# **KIRKLEES METROPOLITAN COUNCIL INVESTMENT & REGENERATION SERVICE**

**DELEGATED DECISION TO DETERMINE PLANNING APPLICATIONS**

| Site Address:         | 231, Wakefield Road, Lepton, Huddersfield, HD8 0DH |
| Description:          | Erection of single storey rear extension           |

DRAWING TITLE
PROPOSED ELEVATIONS

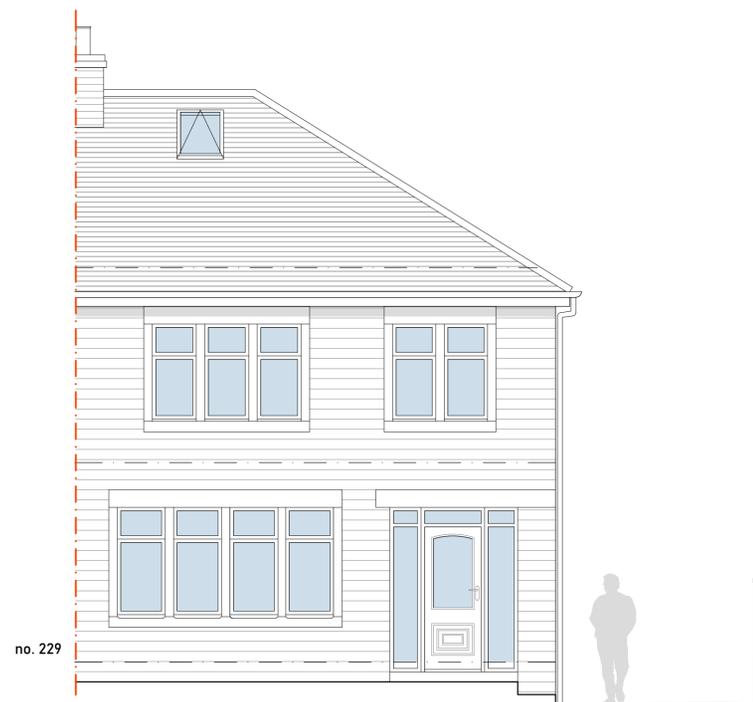
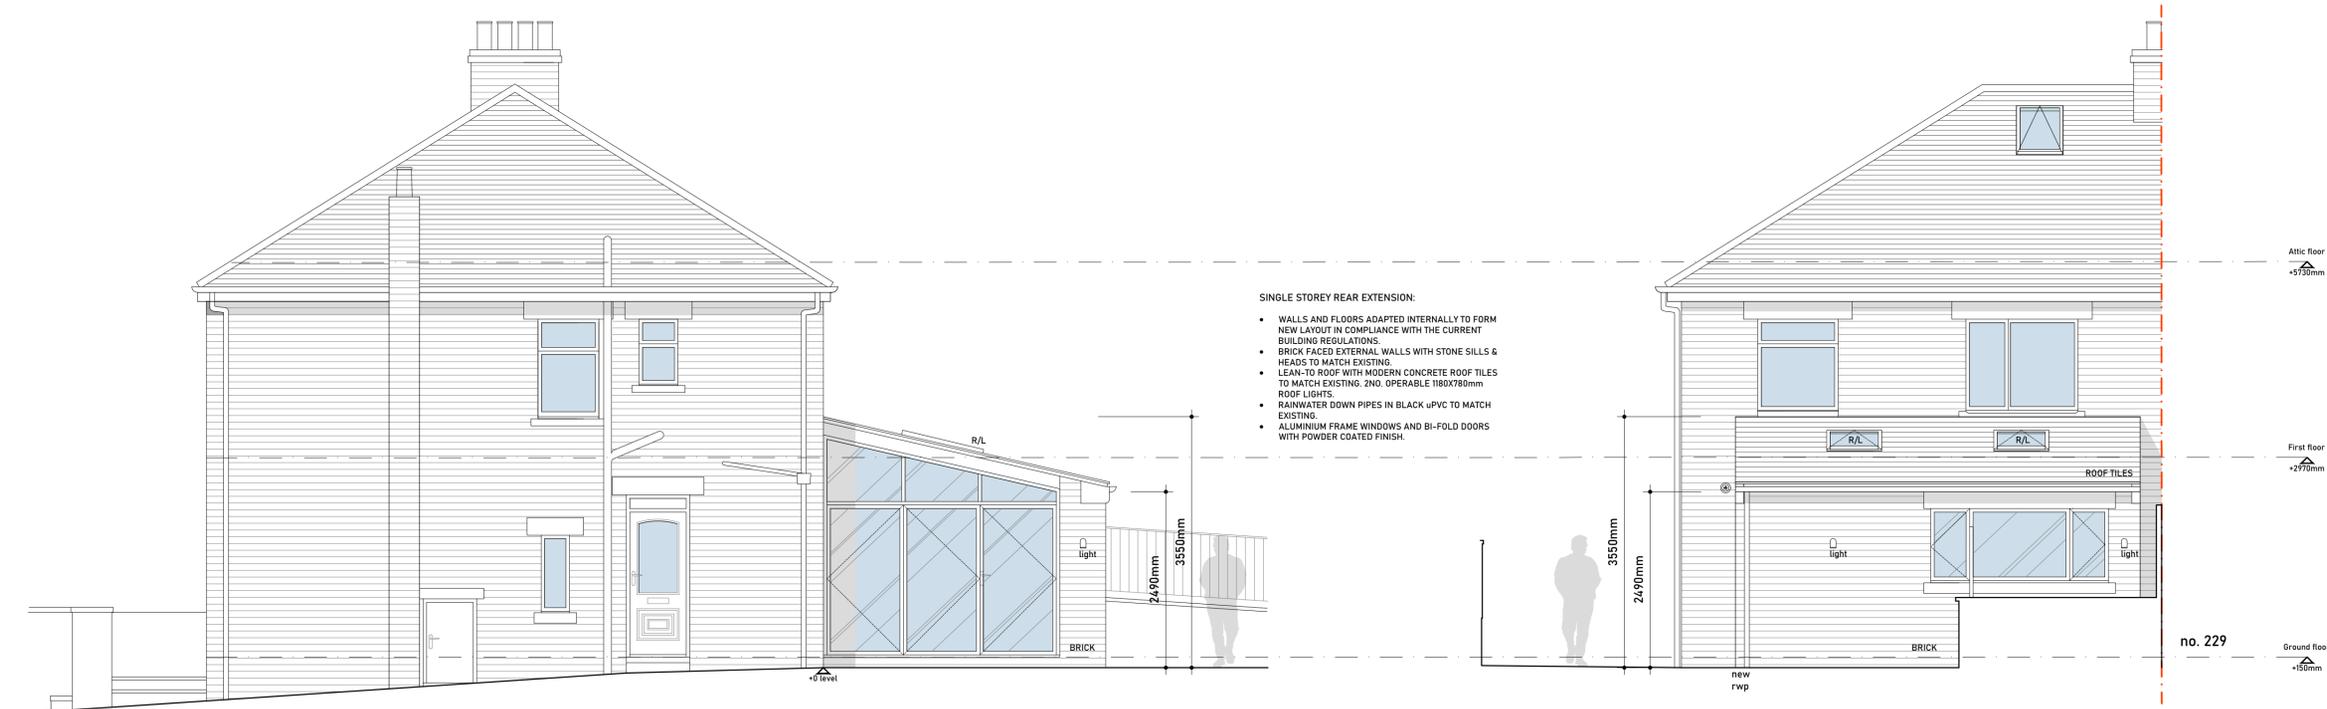
|                                                      | <b>YES / NO</b> | <b>SUMMARY</b>                                                                                                                             |
|------------------------------------------------------|-----------------|--------------------------------------------------------------------------------------------------------------------------------------------|
| Negotiations/Amendments during course of application | Yes             | With regards to the original plans it was suggested that there would be negative impact to the nearest ground floor window to the attached |

|                                     |     | dwelling (no.229) in terms of loss of light. In order to reduce the impact on the adjoining property the agent provided amended plans to show a reduction in the projection of the extension and overall height. |

| not project out more than 3 metres from the rear wall of the original house for semidetached and terraces houses or by 4 metres for detached properties |                                                                                         | No- the projection from the rear wall is 3.5m, however this is justified as there is an existing 2.3m high existing boundary fence with the adjacent neighbour which runs along the whole boundary. In addition, this projection has been reduced from 4m in the original plans to reduce impact. |

DRAWING TITLE
**PROPOSED GROUND FLOOR PLAN,
ROOF PLAN & SITE PLAN**

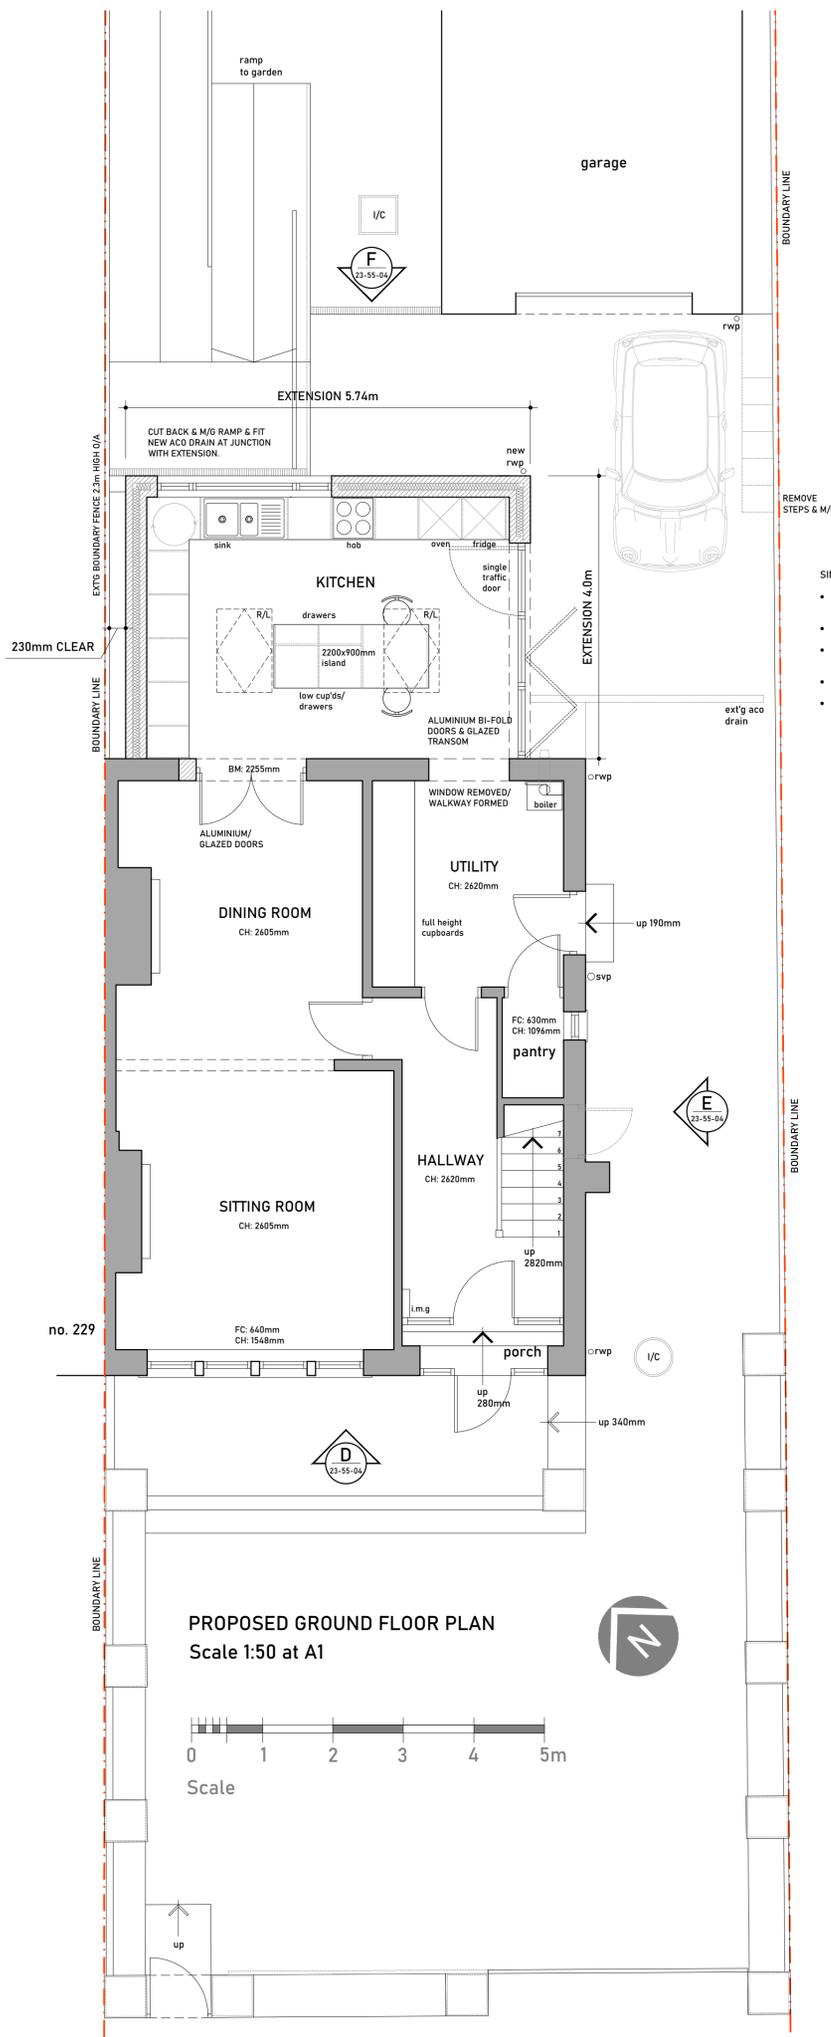
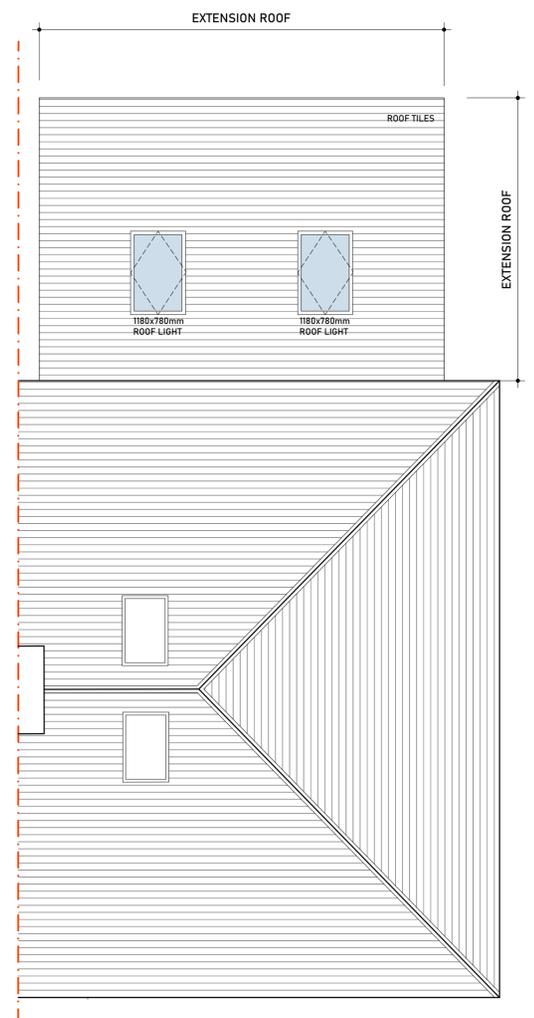
The extension would be 2.49m to eaves, 3.45m maximum height, 3.5m projection and 5.74m width. This would create an open plan kitchen area. The external walls of the extension would be brick faces with stone sills and heads to match existing. The roof would be of a lean-to roof design with modern concrete roof tiles also to match existing. The roof would include two roof lights and the other openings would be aluminium frame windows and bi-fold doors with a power coated finish. The extension would be 230mm clear of the boundary line.

| retain a gap of at least 1 metre from a property boundary, such as a wall, fence or hedge                                                               |                                                                                         | No- the extension would only retain a 0.23m gap from the boundary. However this is justified due to the existing 2.3 meter high existing boundary fence which screens the extension. In addition the reduced height of the eaves reduces negative impacts to the adjoining neighbour.             |
